WATERLOO METRO QUARTER OVER STATION DEVELOPMENT

Basement SSD-10438 -
Response to Submissions

Prepared for
WL DEVELOPER PTY LTD
15 February 2021

Plan of Commercial End-of-trip Facility

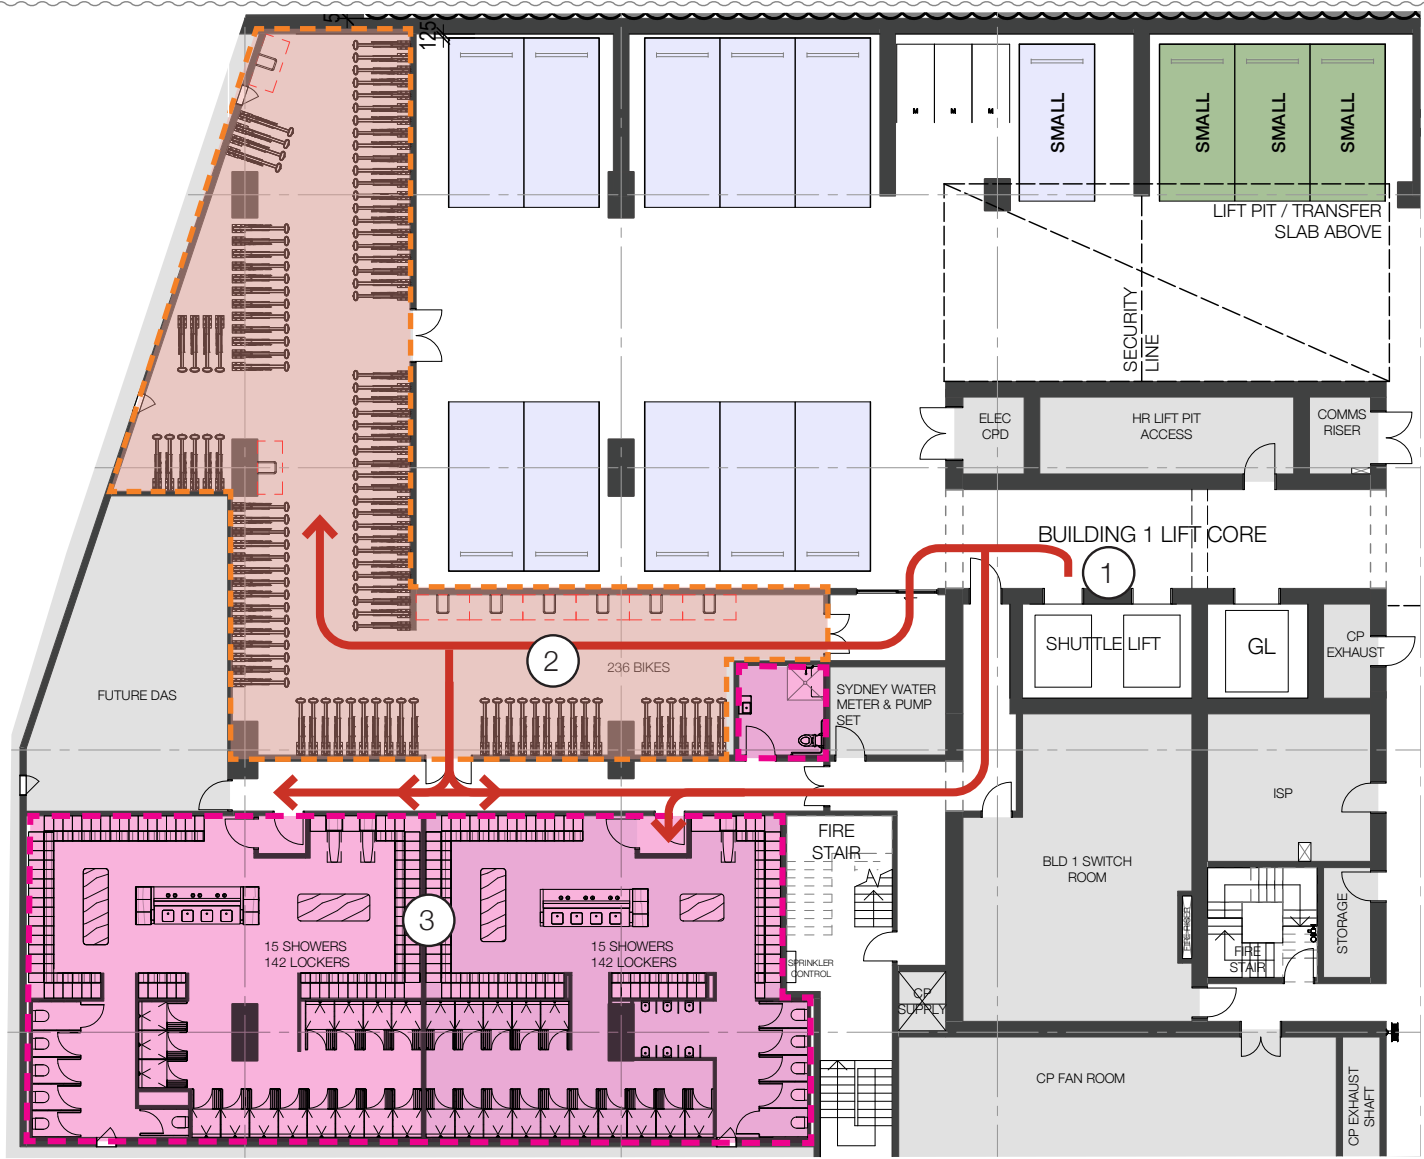
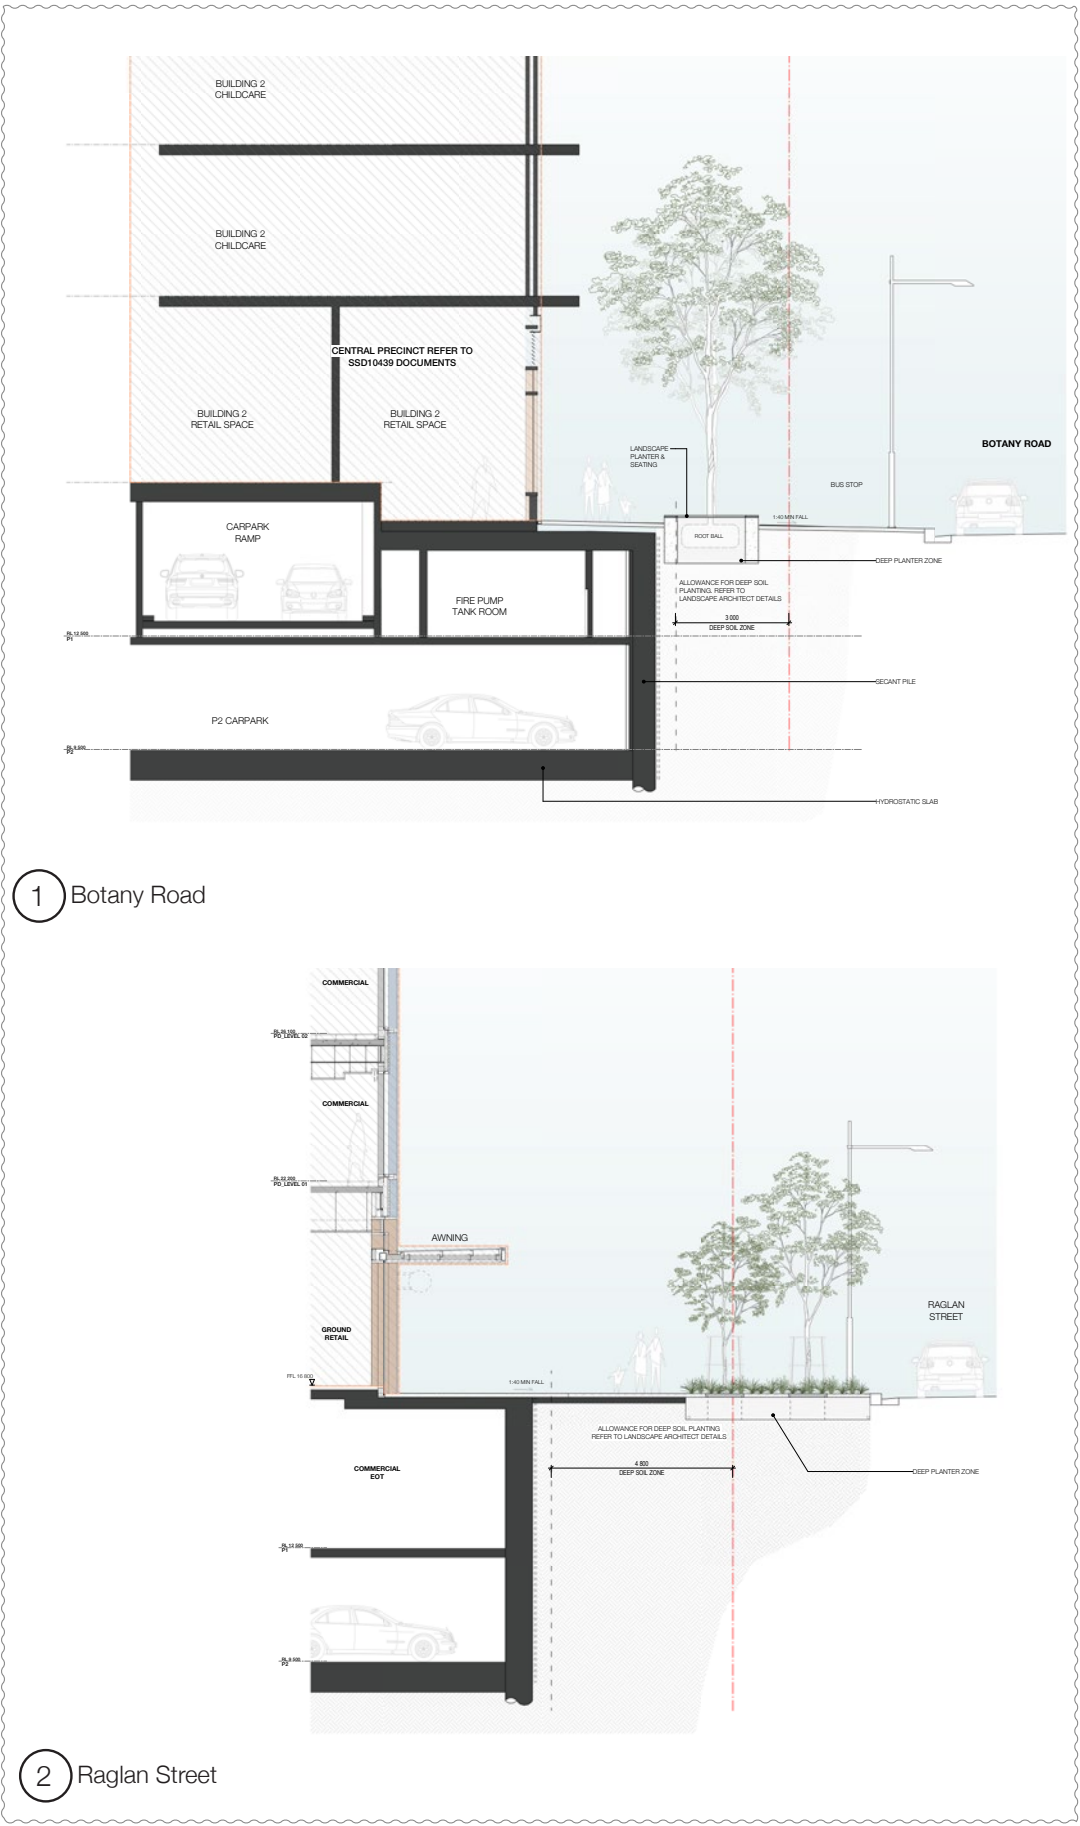
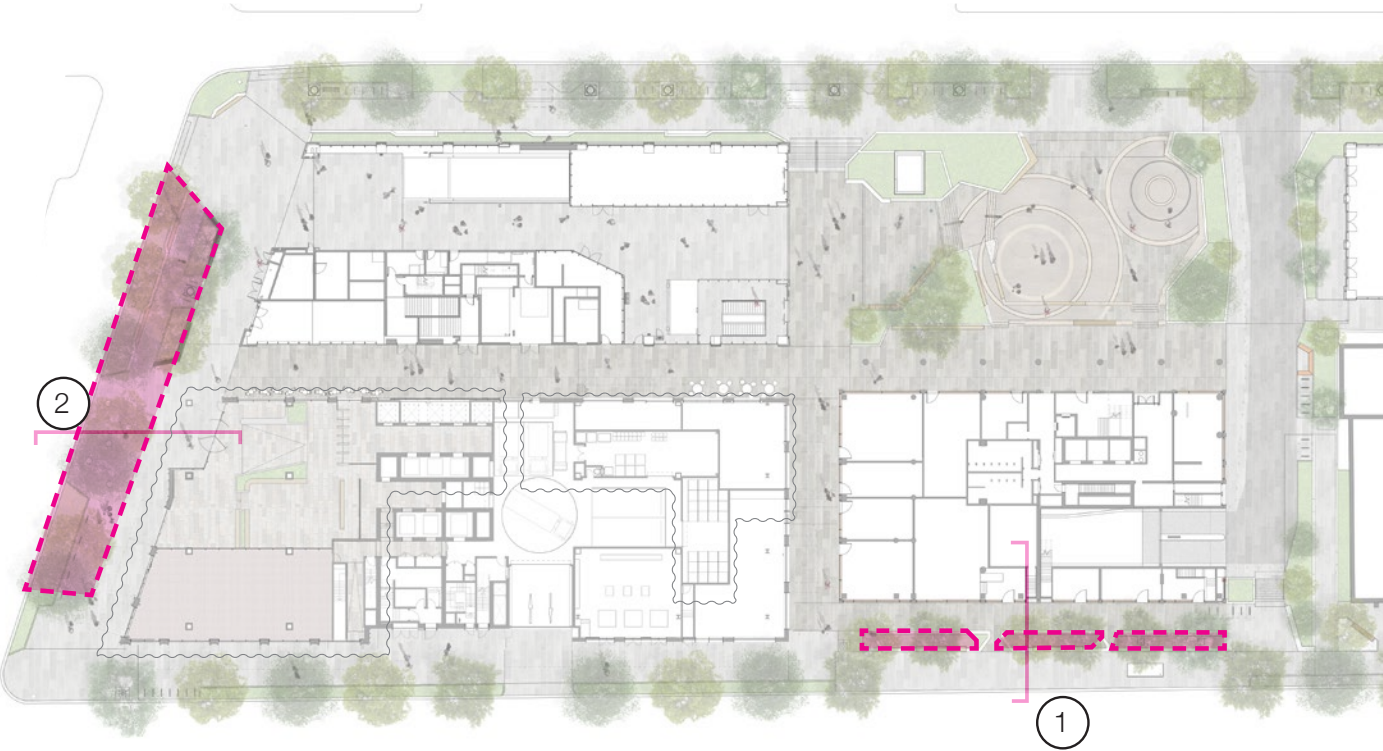
- The end of trip facilities (**EOTF**) layout has been updated and responds to the new basement footprint addressing waterproofing requirements,
 - Motorcycle parking on P1 redistributed from eight (8) spaces to 11 spaces (no change to total),
